Application No: Y/53/22/DOC
Registered: 29th April 2022
Site Address: Land at Stakers Farm North End Road Yapton
Description of Works: Approval of details reserved by condition imposed under Y/44/17/OUT relating to condition 17-as built drawings of implemented scheme.

Following your comments on my email the other day, please find below the response for: Y_53_22_DOC

The construction does not appear to have been carried out in accordance with the design, in addition there are still elements of the construction which are wholly reliant on the contractor's information rather than an independent verifier. As a result, **we would not recommend Discharge of Conditions** until the following information has been provided and following points have been addressed and approved in full.

Scale	NTS	Date	06.08.21
Drawing No	E24121_12	Rev	-

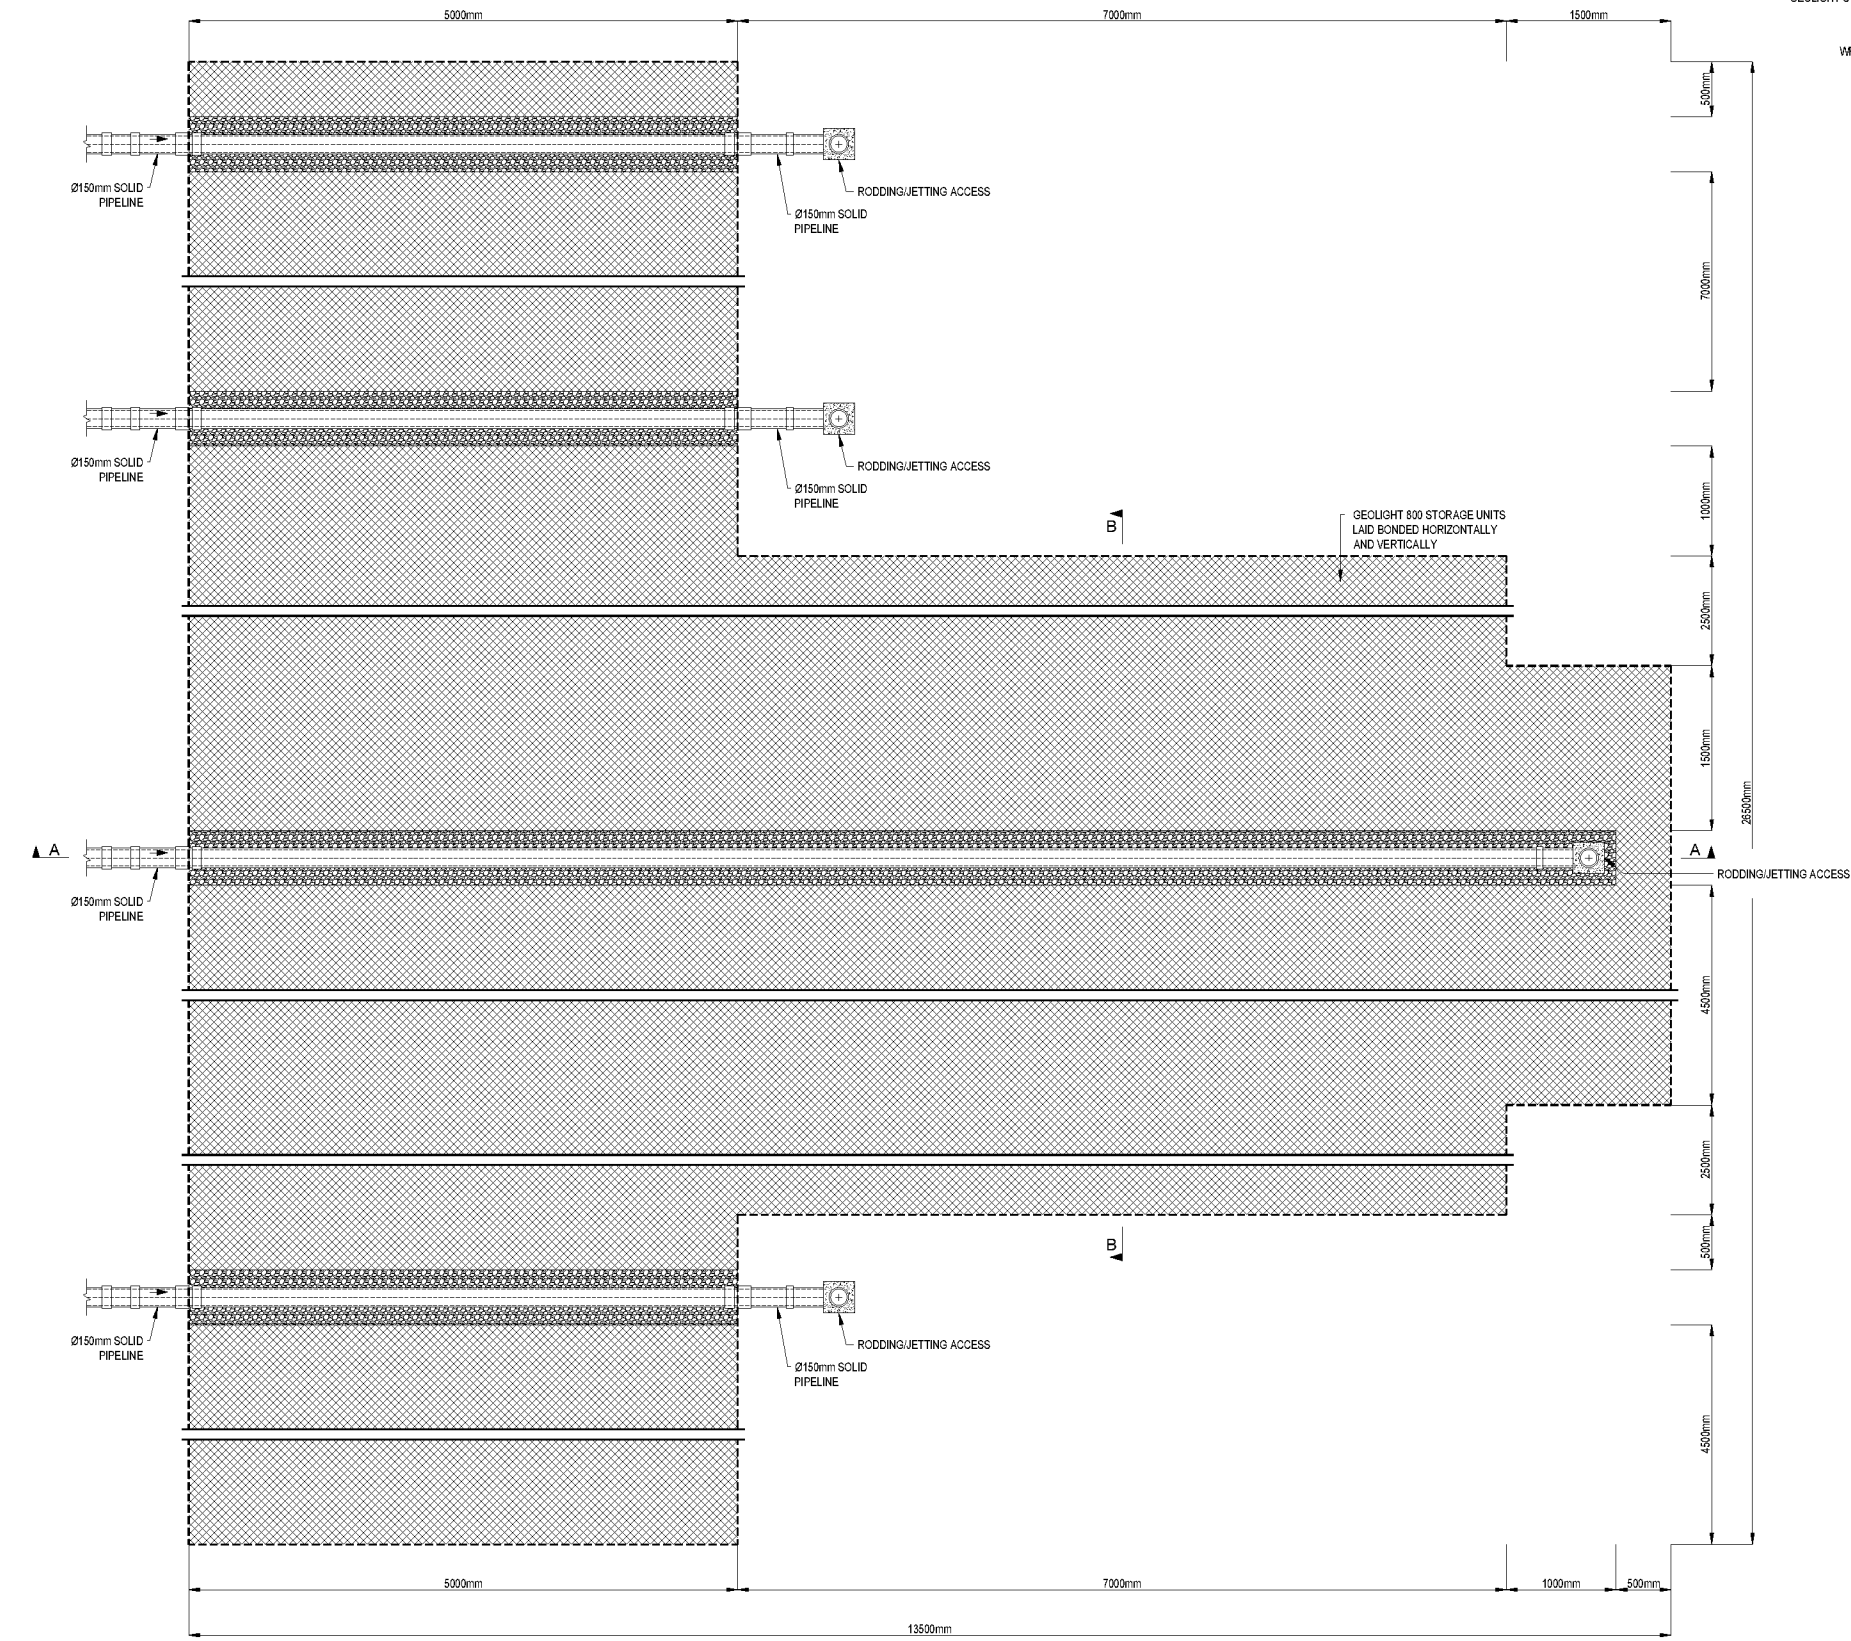
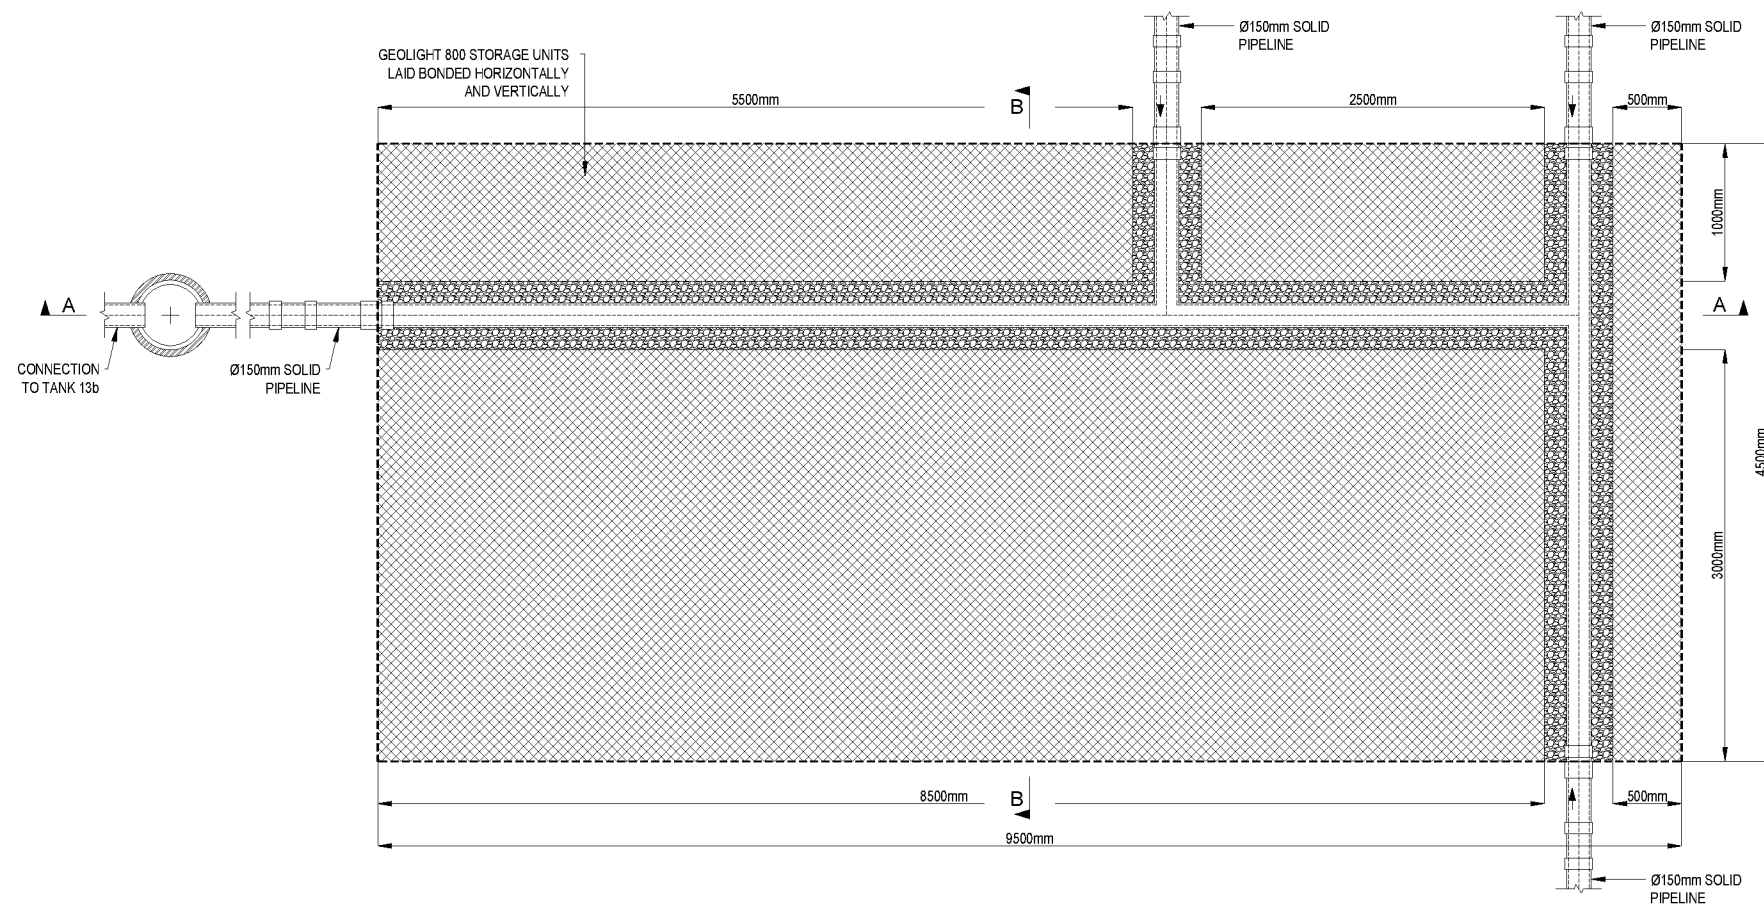
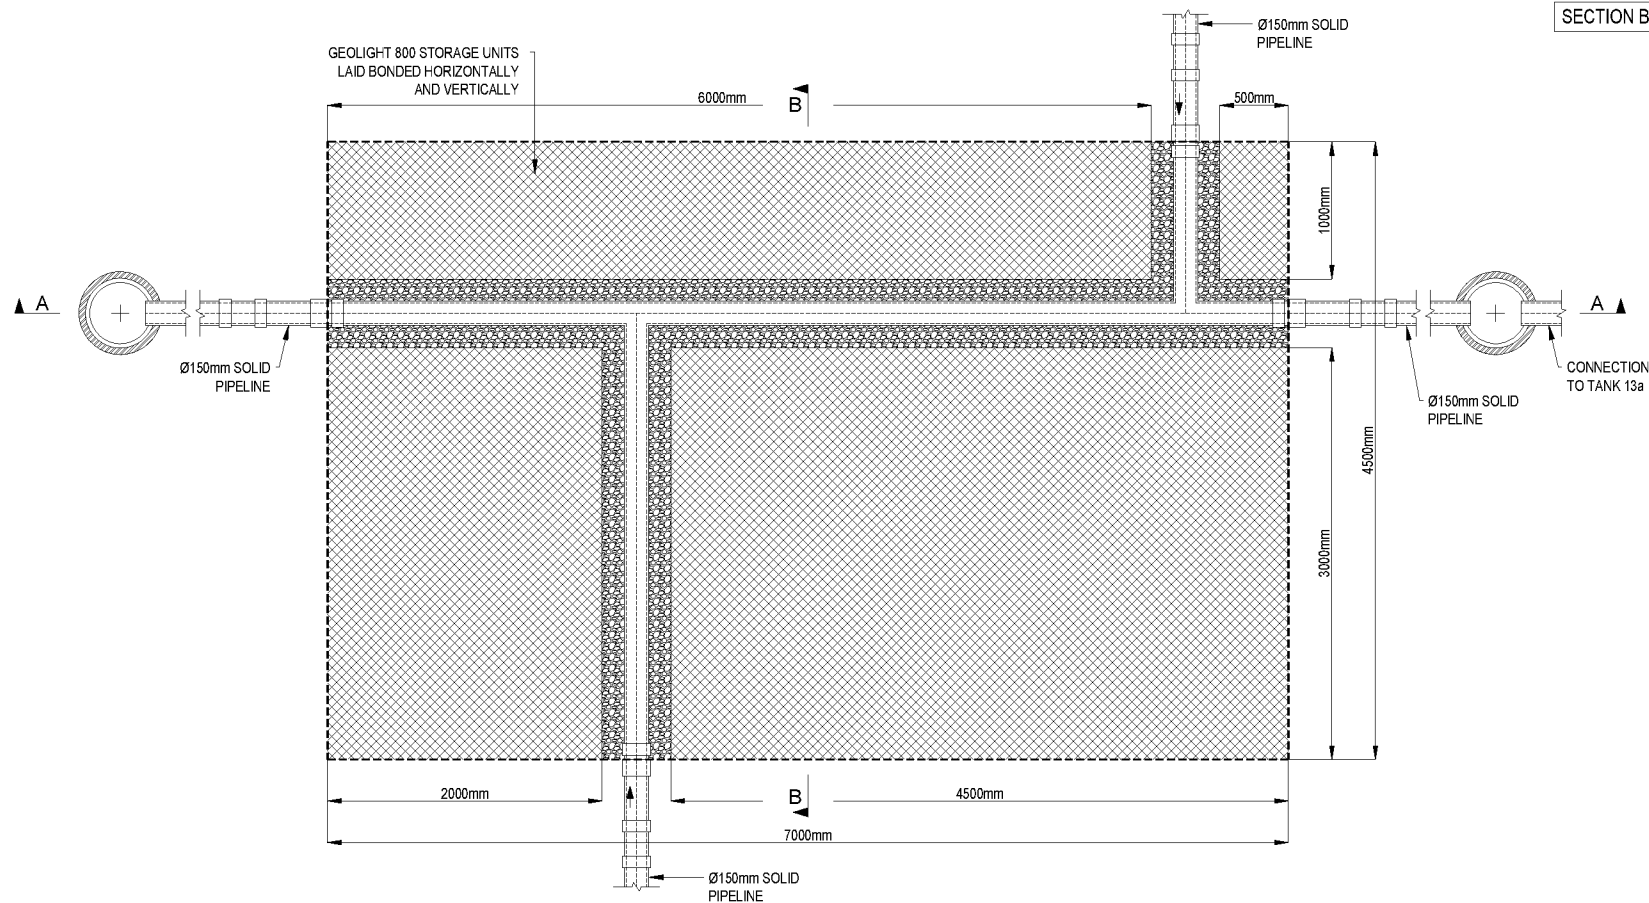
- Checking and remediation of the poorly constructed sediment traps (assuming they are installed as photographed). The sediment traps should be installed as per the submitted drawings. These photographs show several defects in construction including square cut outs used to house round pipes, cracked rims and

plastic, the use of unapproved materials within their construction, rubble filling the base (which visually cannot be confirmed to have been lined) and concrete which appears to have been used as a sealant and is partially blocking one pipe outlet. None of this appears on any of the approved drawings.

- A proposal for remediating these issues should be submitted.
- 4) The letter submitted detailing all of the drawings refers to YAP-180-31 REV C4 however, the submitted planning drawing is Revision C5. The applicant will need to confirm which drawing the contractor was working off and confirm that the scheme was not constructed to an earlier design.
- 5) We also acknowledge significant differences in the levels for the base of the permeable surfacing, and appreciate the revised calculations showing that this will only result in minor flooding in one area of the site. This is noted to occur but is not significant enough to warrant remediation as the volumes are small and flooding only occurs infrequently (based on the model results).
